Rezoning Transportation Analysis

Petition Number: 2023-015

Date	Description
5-24-23	First Review (JT)
10-26-23	Second Review (JP)
12-20-23	Third Review (JP)
2-28-24	Fourth Review (JP)

REZONING SKETCH PLAN

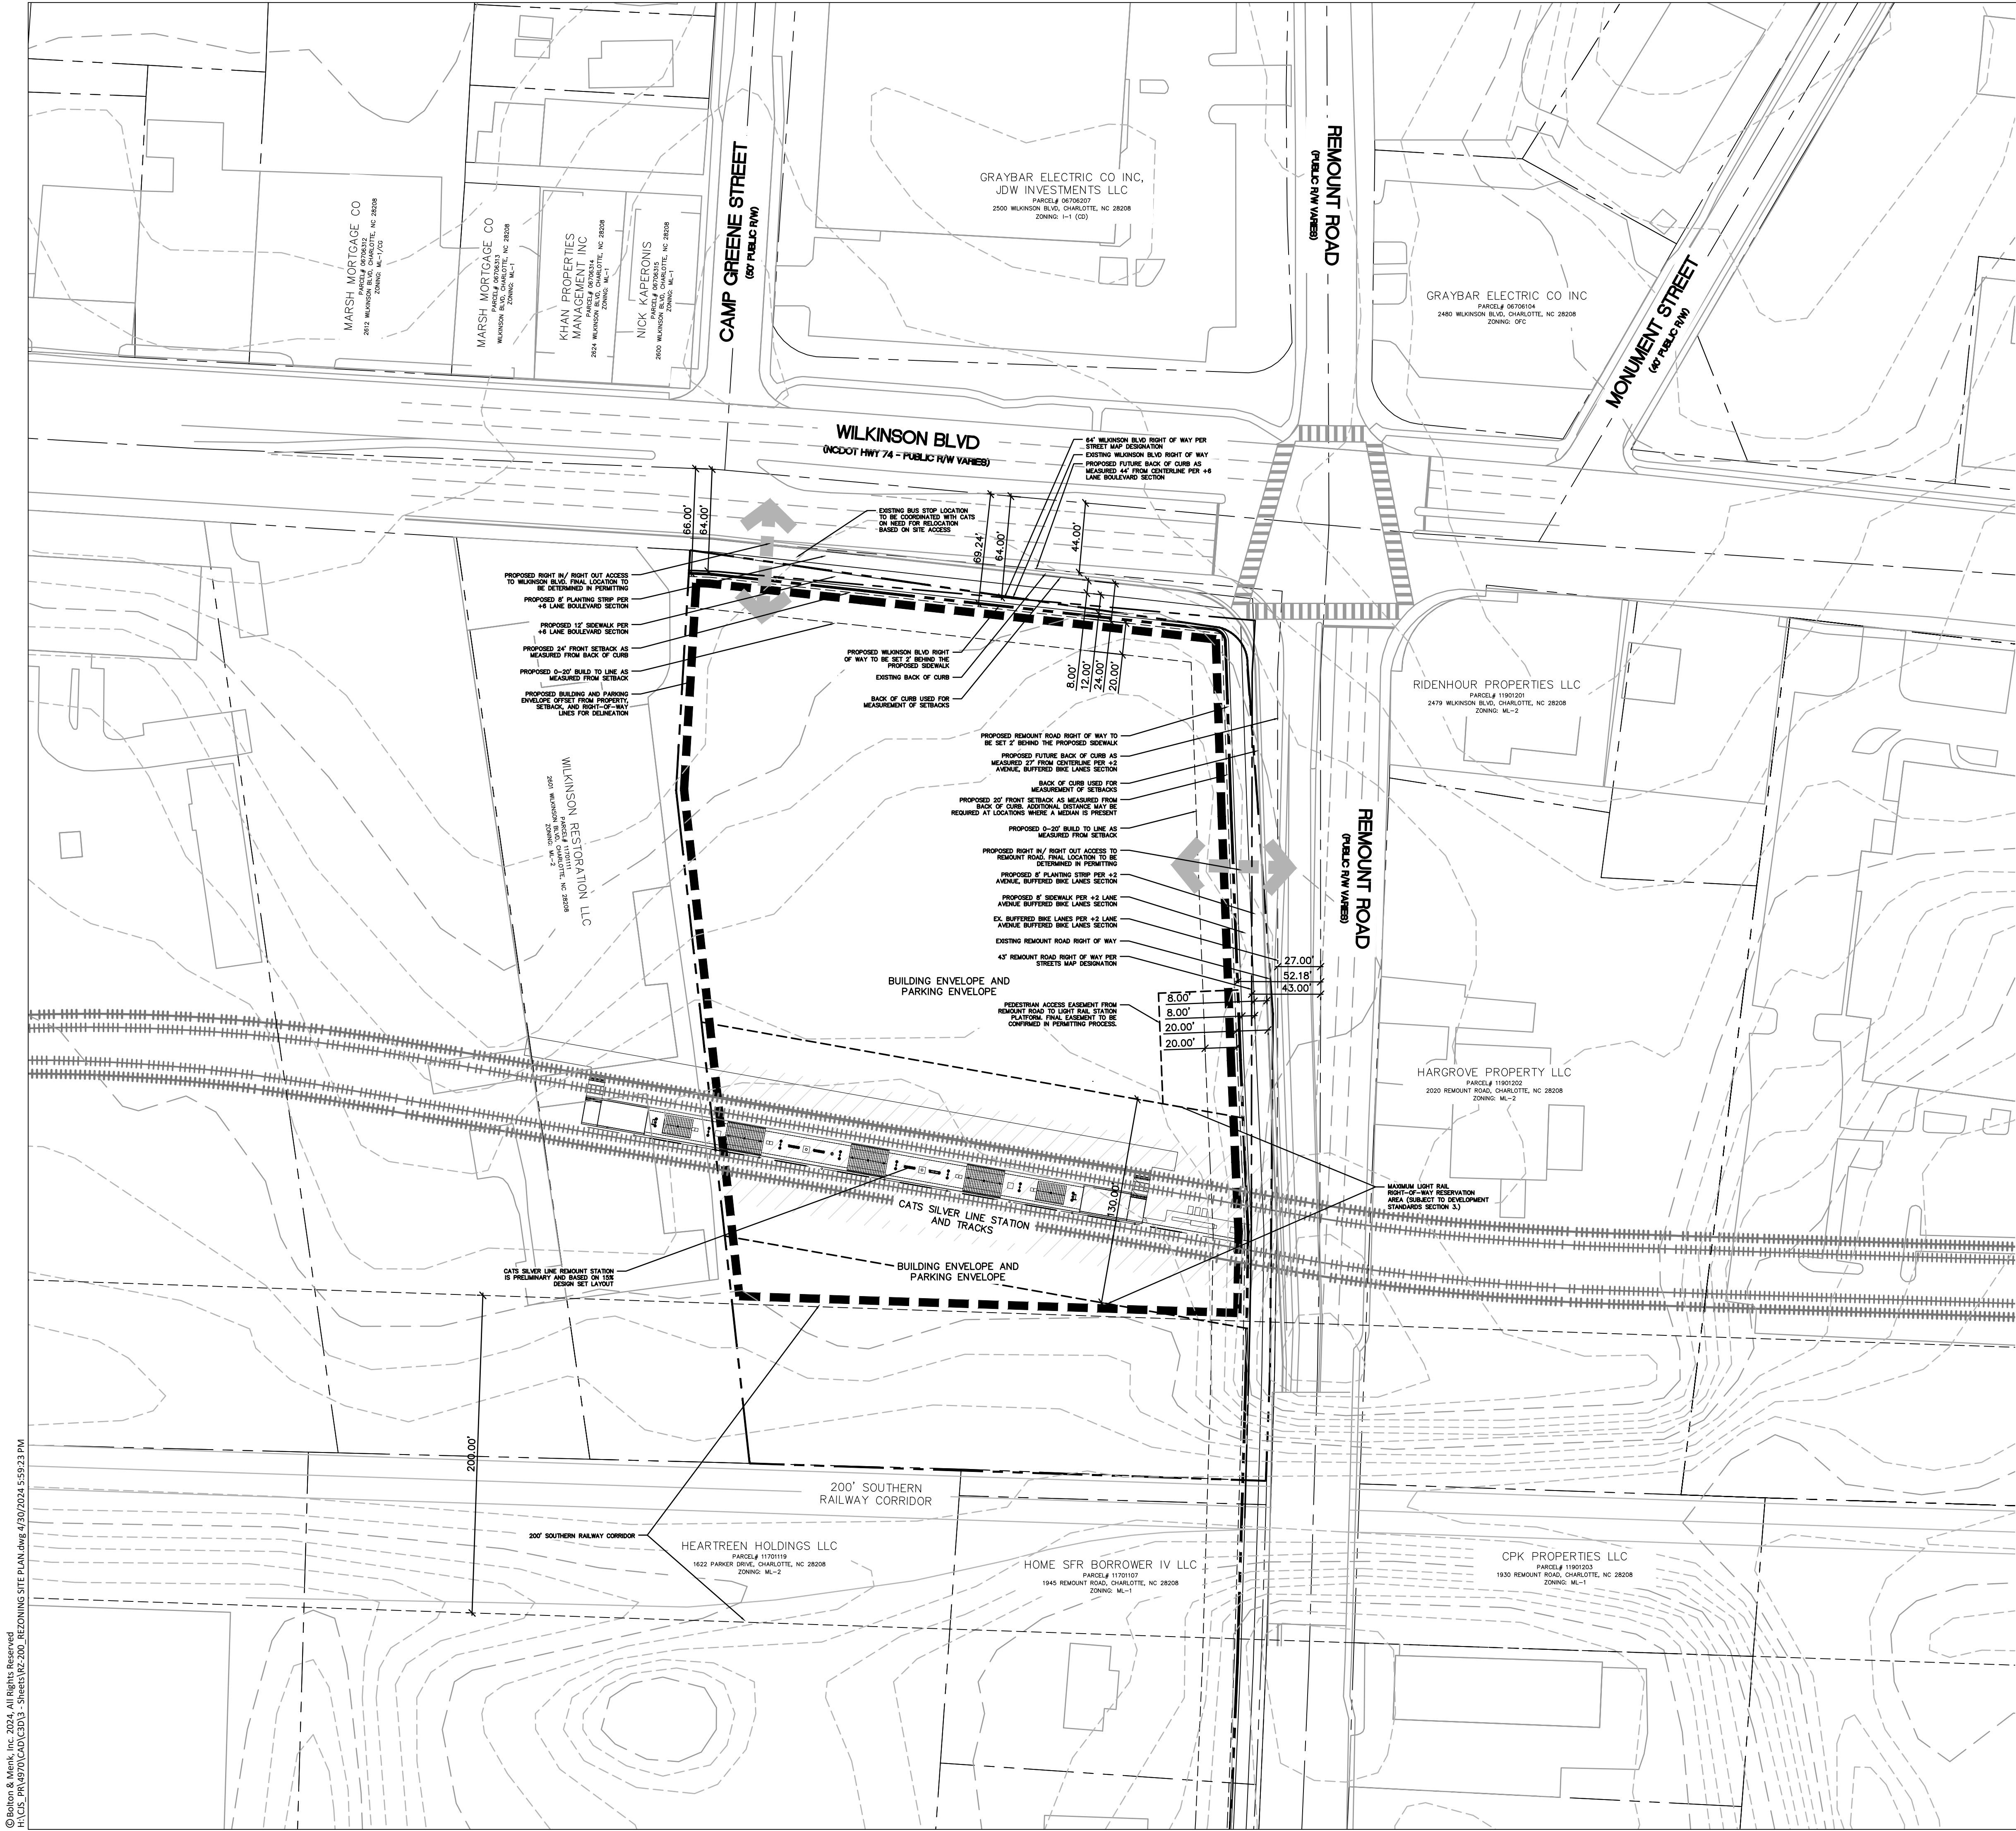
~~**Outstanding Comment 12.20.23:** Label and dimension the curb and gutter from the centerline for each road on the site plan.~~

~~3. Revise site plan and conditional note(s) to label and dimension the right of way from the road centerline.~~

DEVELOPMENT NOTES

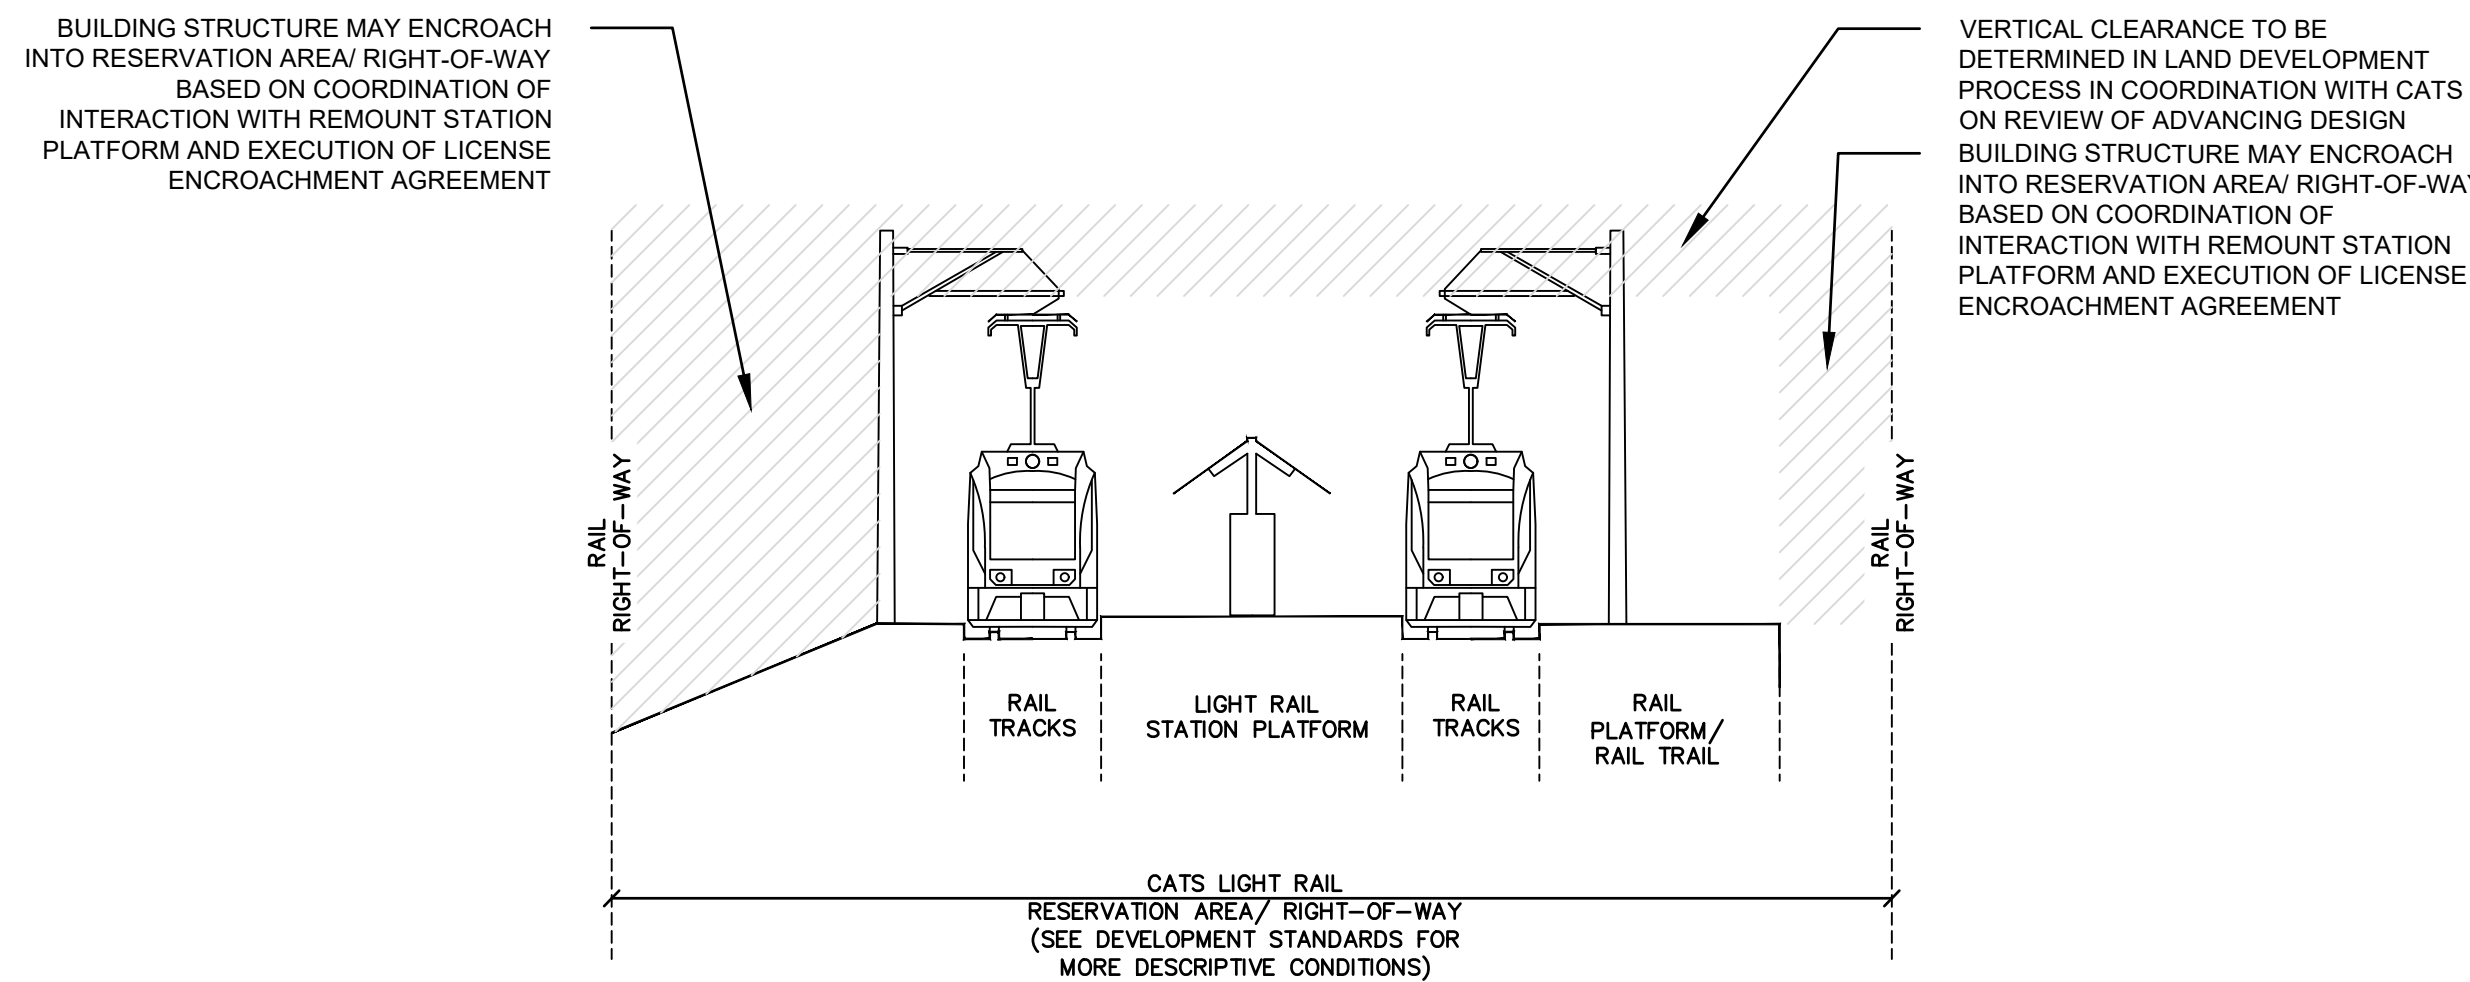
~~**Clarifying Comment 12.21.2023:** Revise conditional note(s) to add, "Petitioner will coordinate with CDOT during permitting for determination of need for TIS based on ordinance requirements and proposed land uses and density."~~

~~4. Add a conditional note specifying "A Right of Way Encroachment Agreement is required for the installation of any non-standard item(s) (irrigation systems, decorative concrete pavement, brick pavers, etc.) within a proposed/existing City-maintained street right of way by a private individual, group, business, or homeowner's/business association. An encroachment agreement must be approved by CDOT prior to construction/installation. Contact CDOT for additional information concerning cost, submittal, and liability insurance coverage requirements."~~

~~5. Add a conditional note specifying "the Petitioner shall dedicate and convey in fee simple all rights-of-way to the City before the site's first building certificate of occupancy is issued. CDOT requests rights-of-way set at 2' behind back of sidewalk where feasible."~~

- ~~6. Add a conditional note specifying "All transportation improvements will be approved and constructed before the site's first building certificate of occupancy is issued."~~

- ~~7. Add conditional note specifying "All public roadway improvements will be subject to the standards and criteria of CDOT and NCDOT, as applicable, to the roadway improvements within their respective road system authority. It is understood that such improvements may be undertaken by the Petitioner on its own or in conjunction with other development or roadway projects taking place within the broad western Mecklenburg area, by way of a private/public partnership effort or other public sector project support."~~
